# City of Albuquerque Stormwater Construction Site Inspection Report

ESC File No.	K15E034A	Project Name:	Broadstone North Block			
NPDES Id. No.	NMR1000VI - NMR1001FJ	Location:	1111 Copper Ave NE			
12/29/2020	Property Owner		Contractor			
Operator	Cedar Investments, LLC CO Argus Dev.		Alliance Residential Builders			
Contact name & title	Josh Rogers		Lee Riley			
e-mail	jrogers@titan-development.com		lriley@allresco.com			
Contact Phone #	505-998-0163		505-264-7022			
COA Inspector	Doug Hughes		Start/End Time:	8am		
Construction Phase:	Vertical					
Type of Inspection:	<input checked="" type="checkbox"/> Regular	<input type="checkbox"/> Storm Event	<input type="checkbox"/> Post Storm Event >0.25"	<input type="checkbox"/> 311/Complaint	<input type="checkbox"/> Follow Up	
Weather at time of inspection?		Cloudy		Temperature: ~	40	
Estimated date of last storm 0.25" or greater			12/11/2020

EROSION AND SEDIMENT CONTROL PLAN

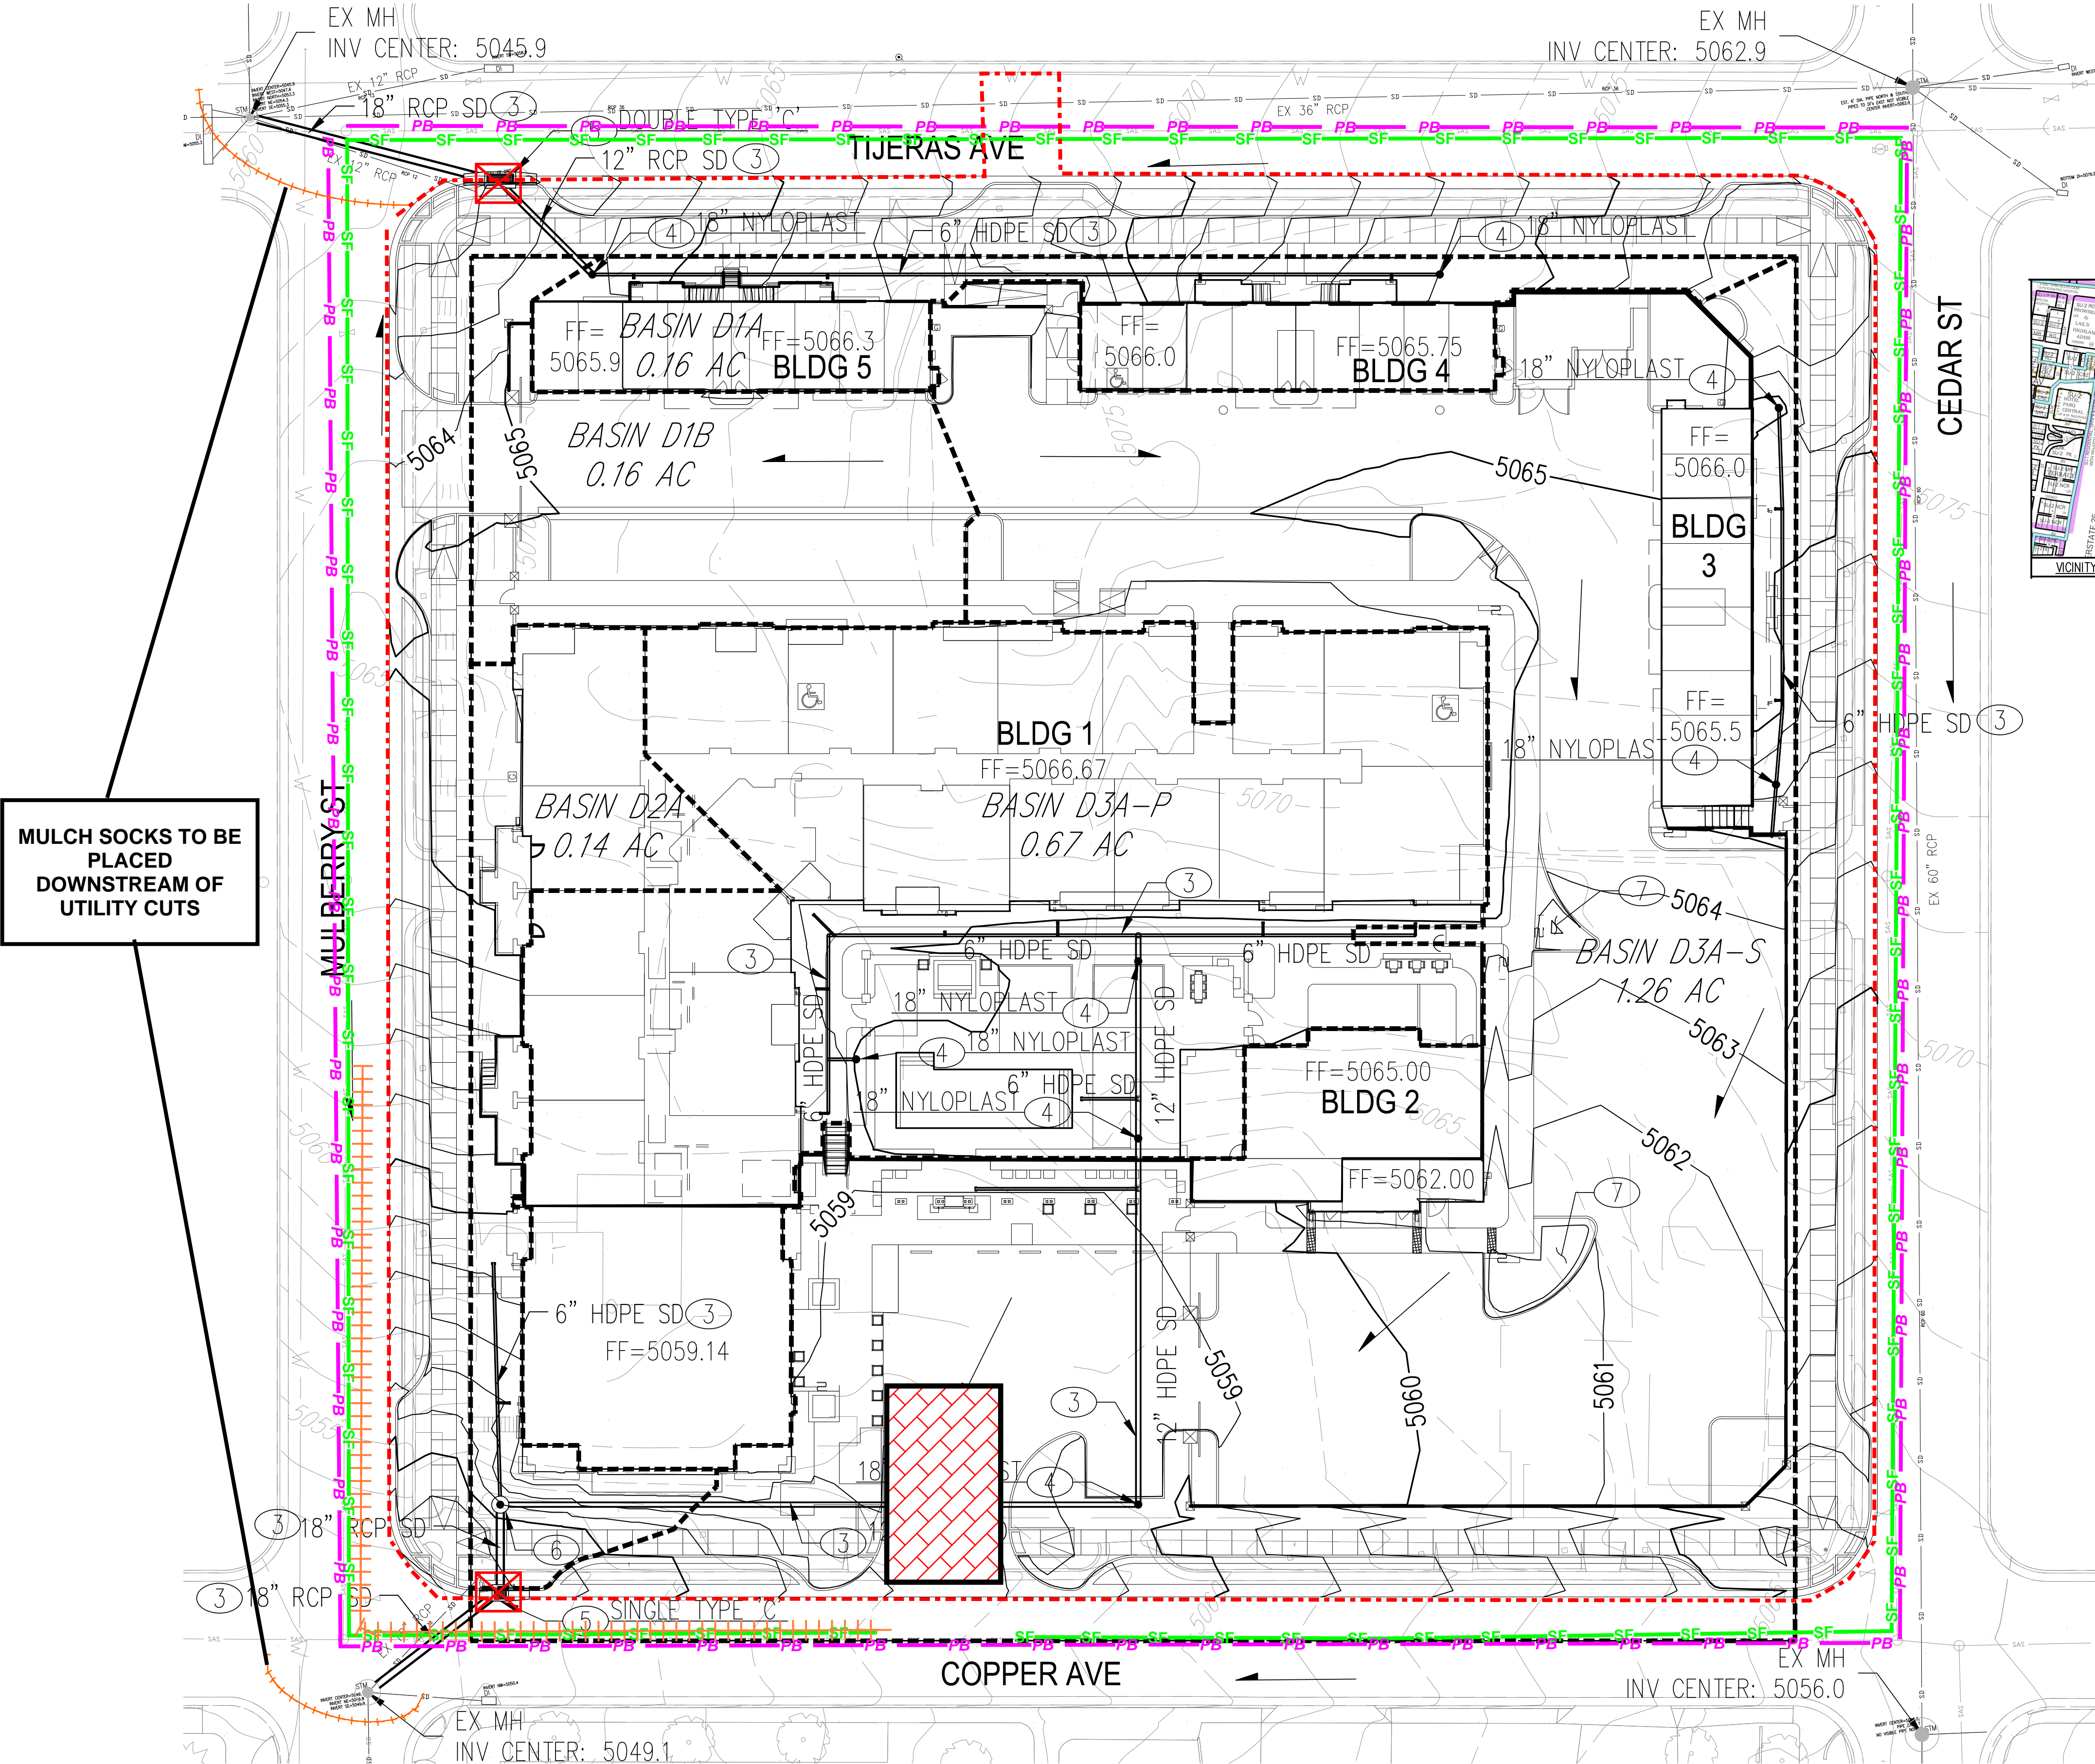
Item Number	Deficiency/ Corrective Action					
1	Sediment in Street trackout and leaks under silt fence on Cedar. Please remove sediment.					
2						
3						
4
